Planning Application Ref: FP/101/17/T

Location: 7 Wellers Close, Felpham

Description of works: Monterey Pine to be topped and sides reduced by 3m & crown clean by 20% & deadwood

Request for Tree work

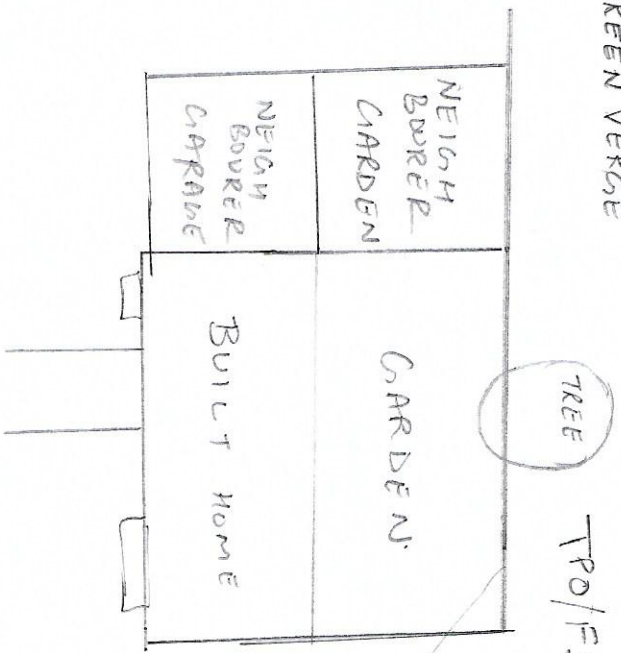
- A mature tree of significant proportions that has sadly been neglected in terms of management and contains a lot of storm damaged and broken and lodged limbs as well as a lot of large diameter deadwood. Has a low branching habit down to within 2m to 3m of ground.
- It has been retained in too close to a new plot and thus causes intense shading and has heavy branch overhang of the garden with safety concerns ensuing.
- It is understood that the tree is in the ownership of the developer of this land but written permission has been issued to the owner to carry out the pruning subject to obtaining Council approval to same.

- I recommend **APPROVAL** of this application – with the proviso that the lateral spread reduction is undertaken all around the crown in a balance fashion and not just on the side facing the garden – otherwise the tree would be left in an unbalanced condition contrary to good arboricultural practice and the recommendations of BS3998:2010.
